Introduction

1. Following the assessment of the three cumulative Transportation Assessments (TAs) for the Pagham residential developments, and due in part to the significant variation between the analysis results from those reports, but also in light of comments about robustness, the recommendation was made that a Sensitivity Analysis of certain junctions be undertaken.

2. The purpose of the Sensitivity Analysis by DBA is in order for Arun District Council (ADC) to be able to inform members on the sensitivity of the impact of the identified sites, and the robustness of conclusions on traffic impact and mitigation. There are a number of issues relating to proposed improvements and absence of improvements that are considered in this report, prior to a final position being stated. The phasing of improvements also needs to be considered by ADC.

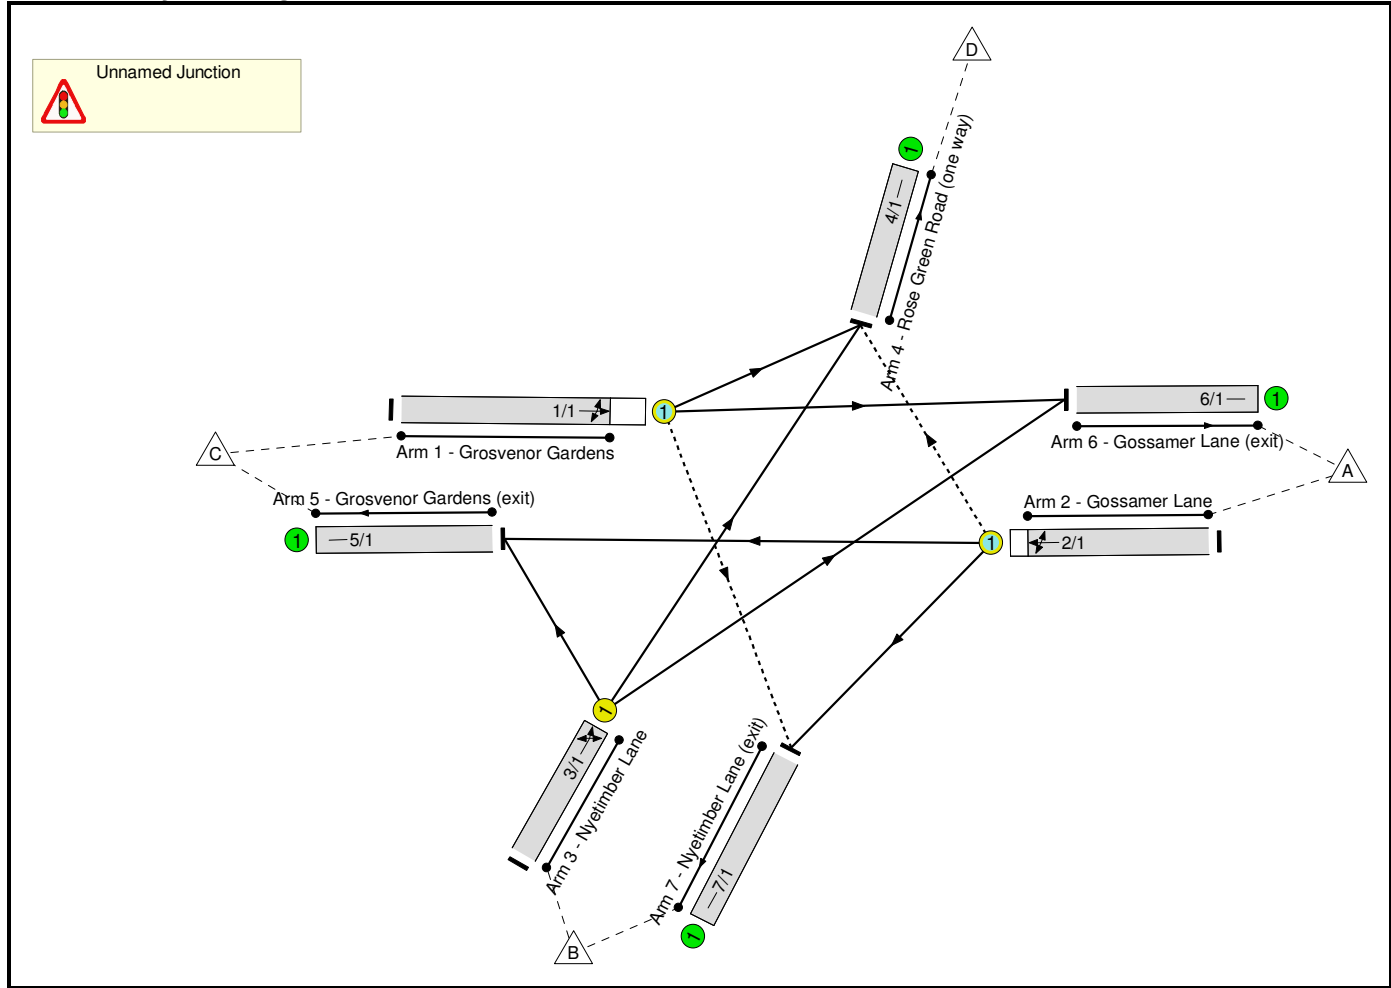
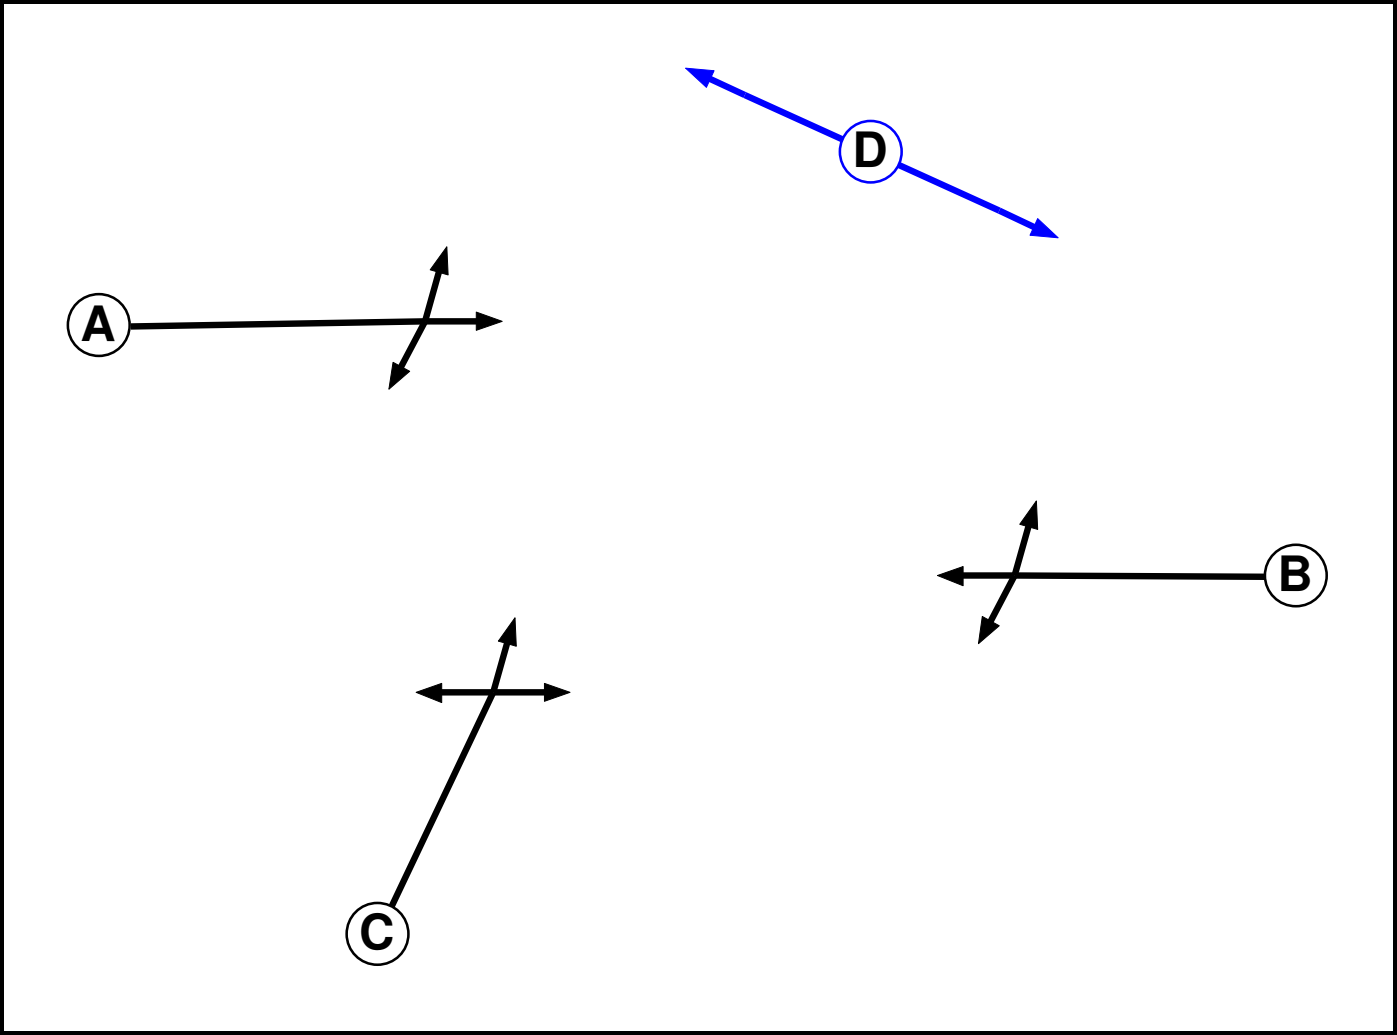
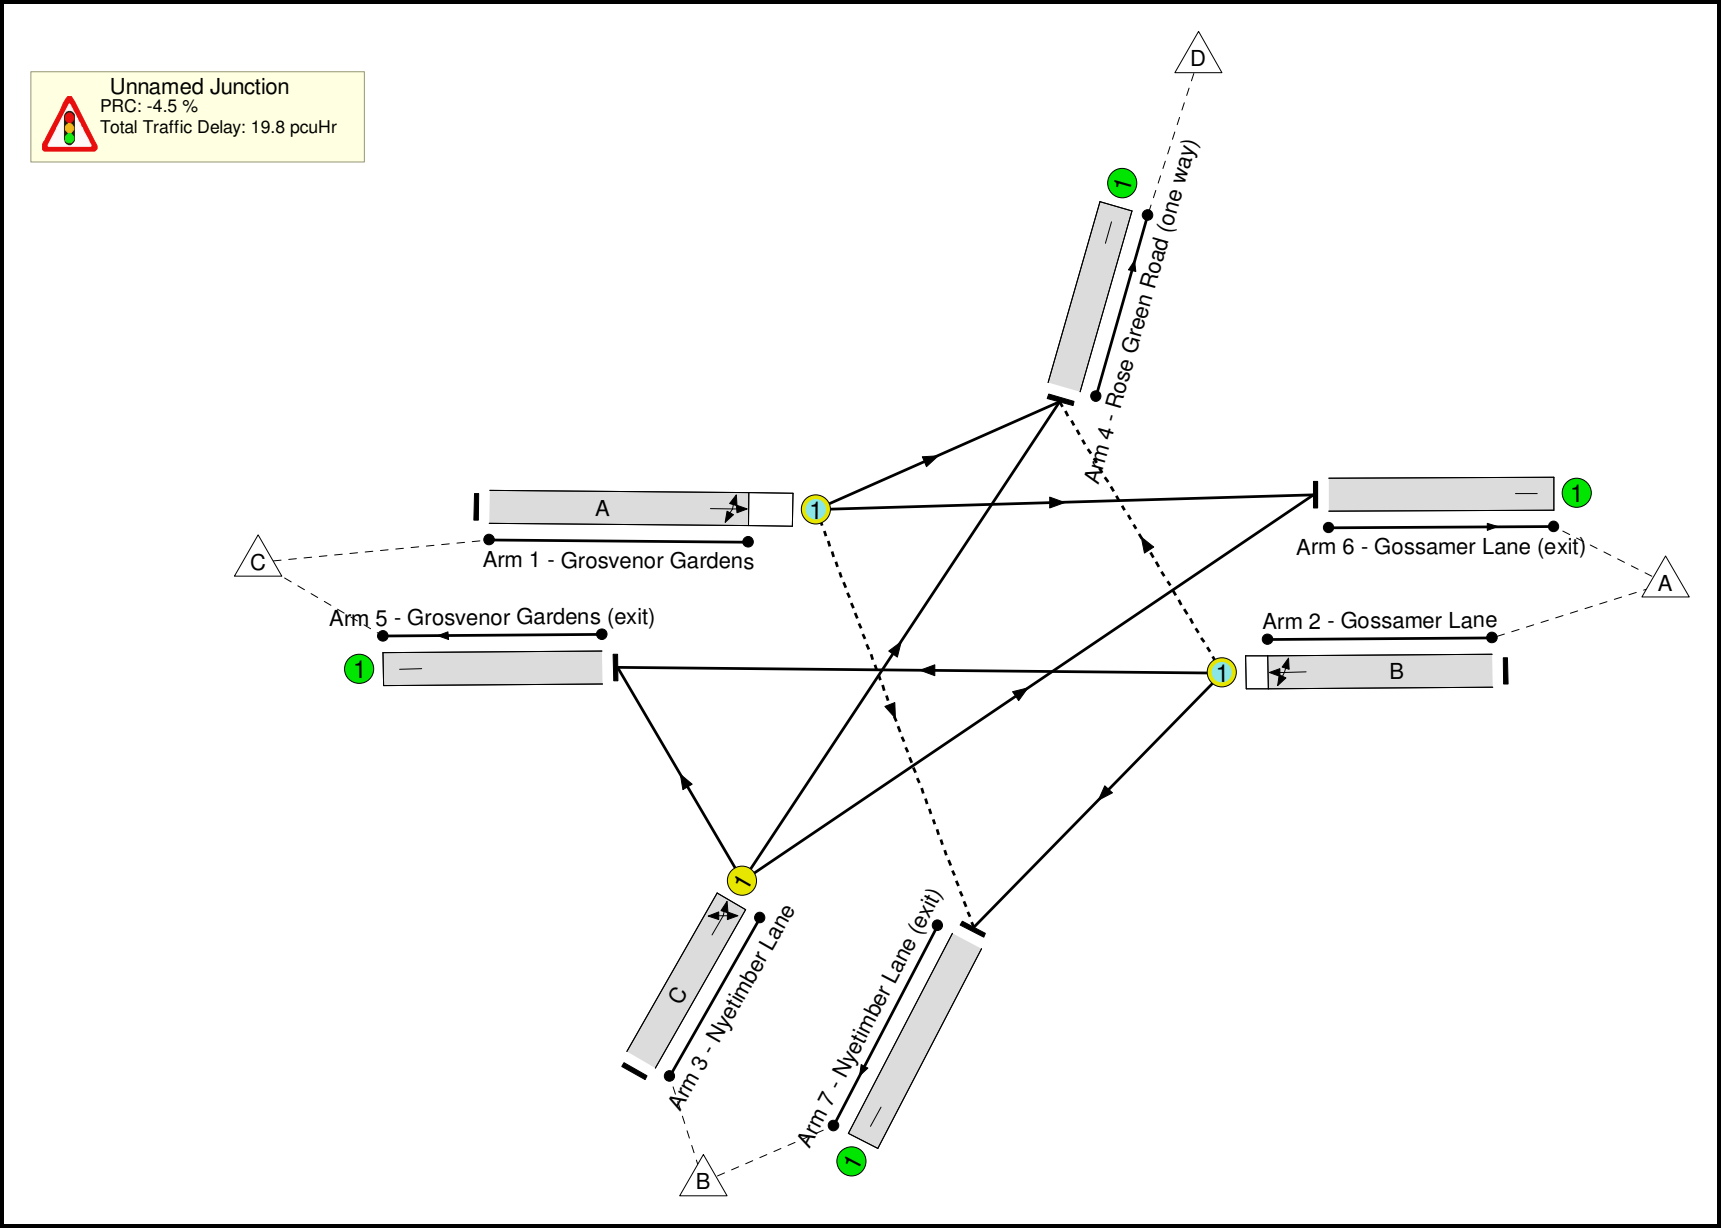
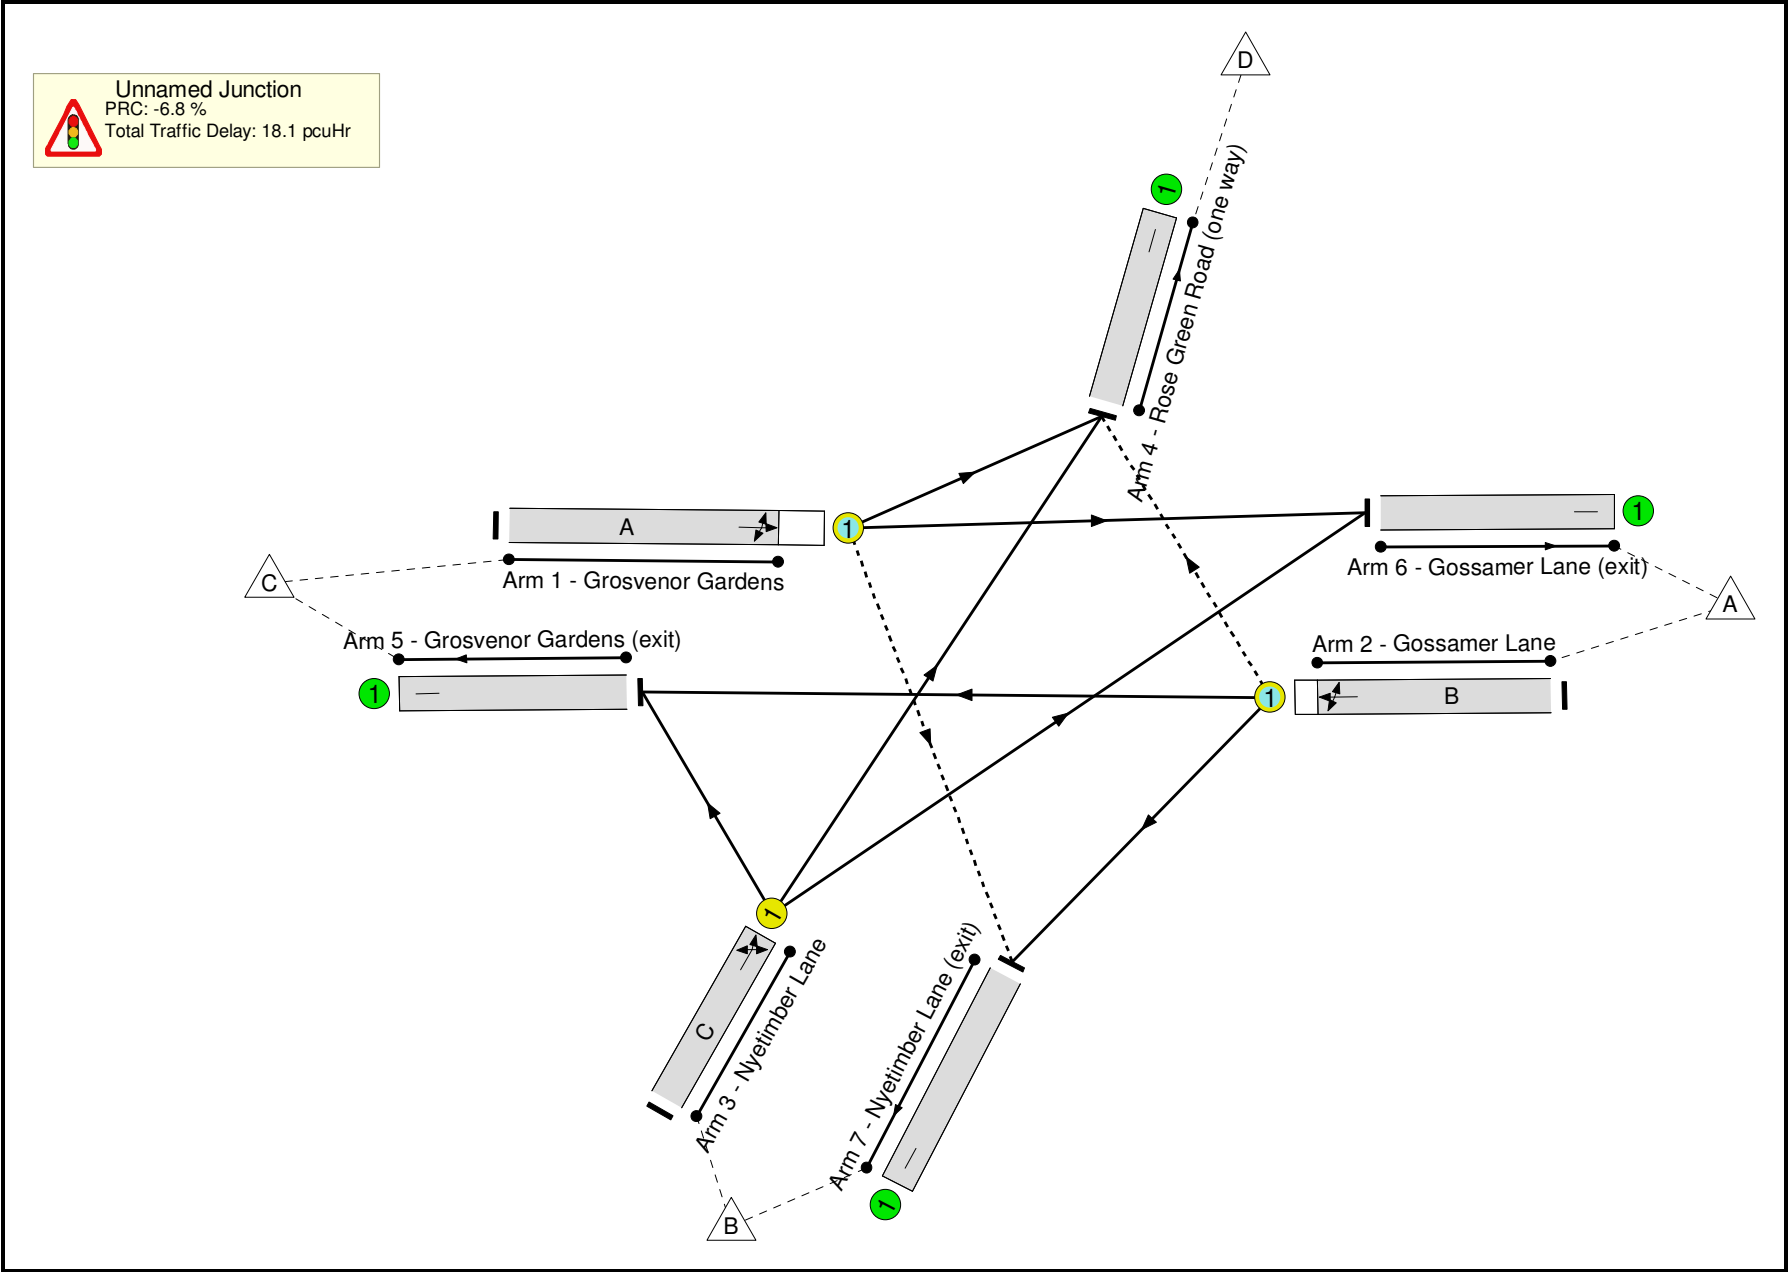
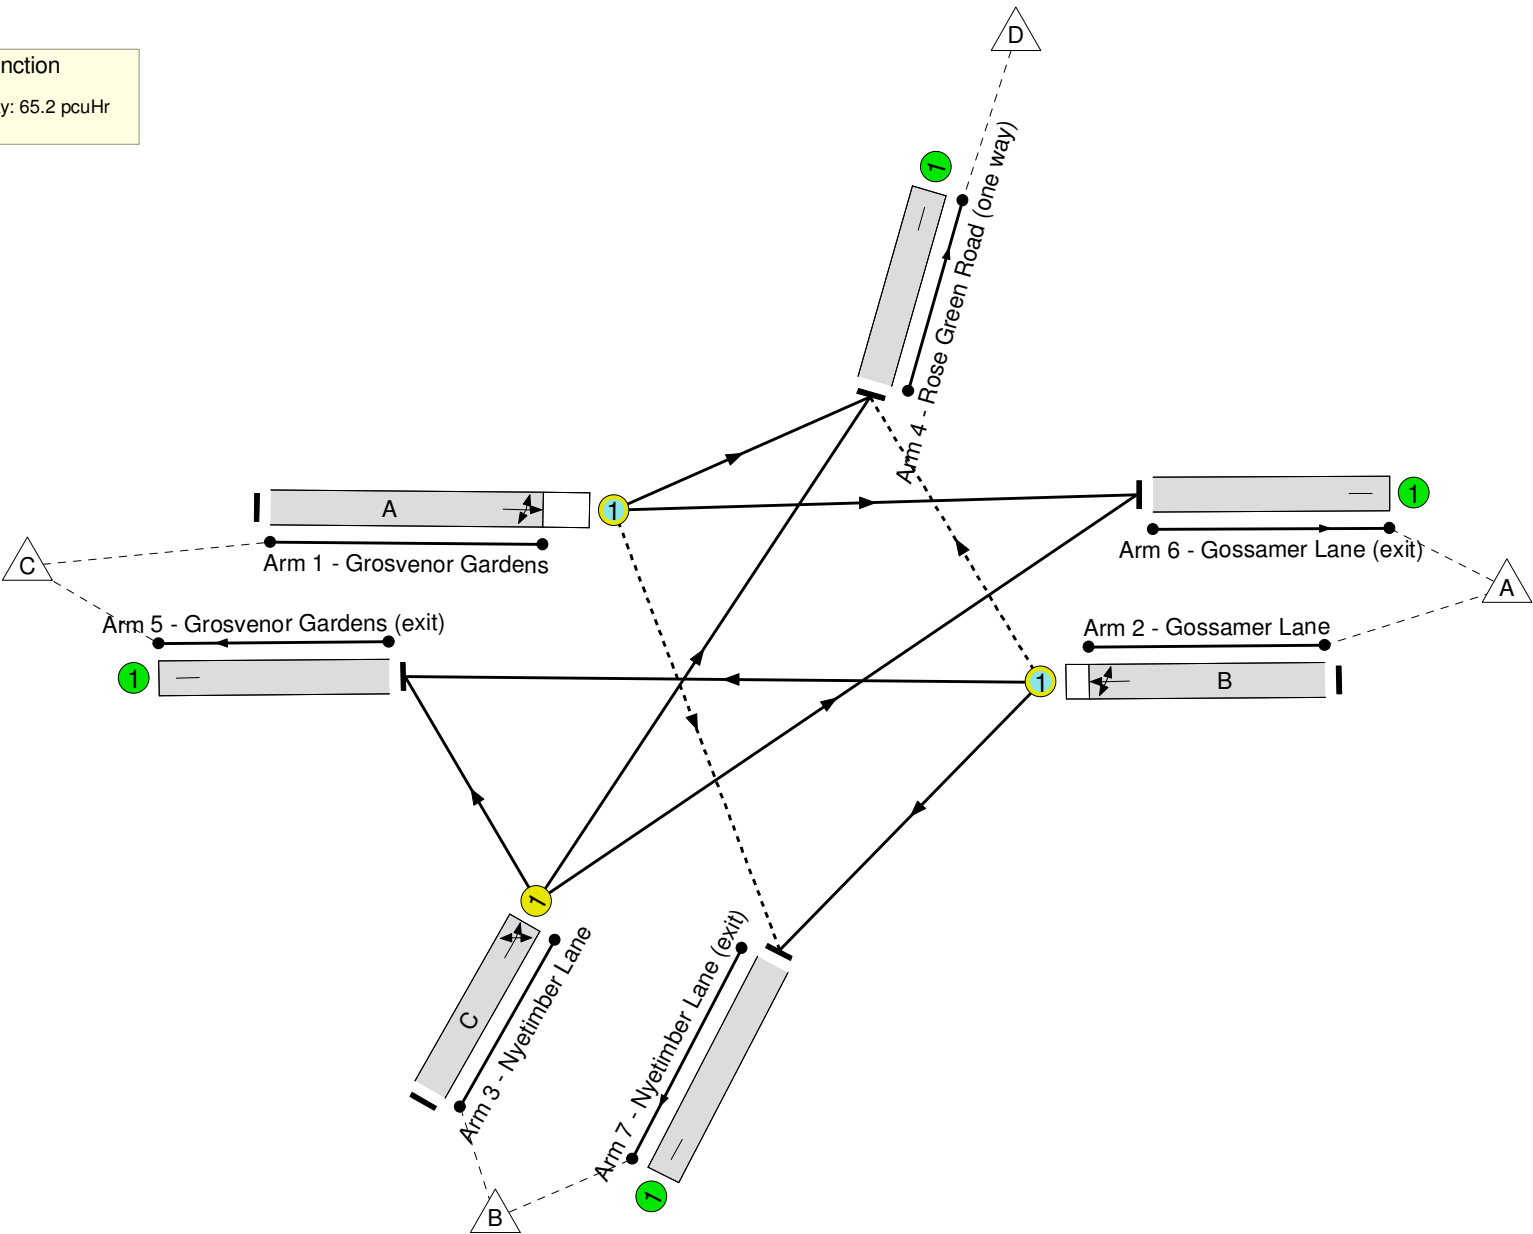
28. On review of the models presented, a particular issue noted was the green time applied to the pedestrian stage. This shows a 7-second green time for pedestrians with no preceding inter-green time separating the pedestrian crossing stage from the previous traffic stage. The inter-green following the pedestrian stage is shown as only 2 seconds. It is not known whether these are confirmed timings on the ground, but in any case they are fundamentally substandard according to pedestrian crossing design requirements, as set out in the Design Manual for Roads and Bridges (DMRB).

29. Notwithstanding the above, DBA have modelled both the presented situation (in the Pagham TAs) and a situation with more appropriate inter-green times. Similarly, in respect of signal total cycle time, it is noted that 90 seconds has been applied without variation. This Sensitivity Analysis considers the effect of a longer cycle time (up to maximum 120 second) to assess whether any benefits would result.

31. DBA's sensitivity test of the signal timings applies a preceding inter-green of 8 seconds, and a following inter-green of 7 seconds to the pedestrian stage at this junction. The result is 2031 committed base results of 91.1% DoS (PRC -1.2%) AM and 90.6% DoS (PRC -0.6%) in the PM. Including sensitivity combined development traffic results in 96.8% DoS (PRC -7.5%) AM peak and 97.5% (-8.3%) PM peak.

32. It is important to note that, if the pedestrian stage is not called, and all of the 90-second cycle is devoted to traffic stages, the maximum DoS values are 74.3% (AM) and 73.8% (PM), with PRCs of 21.1% (AM) and 22.0% (PM). In the absence of actual survey data, it seems likely that the reality would be a pedestrian stage that is called not in every cycle of the lights, but in a proportion of the cycles in the peak hours. This, for practical purposes, the results for future junction operation would lie somewhere between the highest sensitivity results and the no-pedestrian stage values.

45. **Grosvenor Gardens / Rose Green Road signals** – If the signal timings presented in the Pagham TAs are applied, sensitivity analysis indicates that the proposed development traffic would be accommodated at this junction in the future design year. If timings are applied to the pedestrian stage that take account of current standards and the requirements of pedestrian safety, modelled development impact would be higher. The question of whether combined development traffic would be accommodated with suitable signal timings depends on pedestrian stage call frequency during peak hours. In the absence of specific data, and given the nature of the location, it is considered reasonable that a balance would be struck favouring pedestrian safety. It is concluded therefore that no mitigation works would be required in this location.
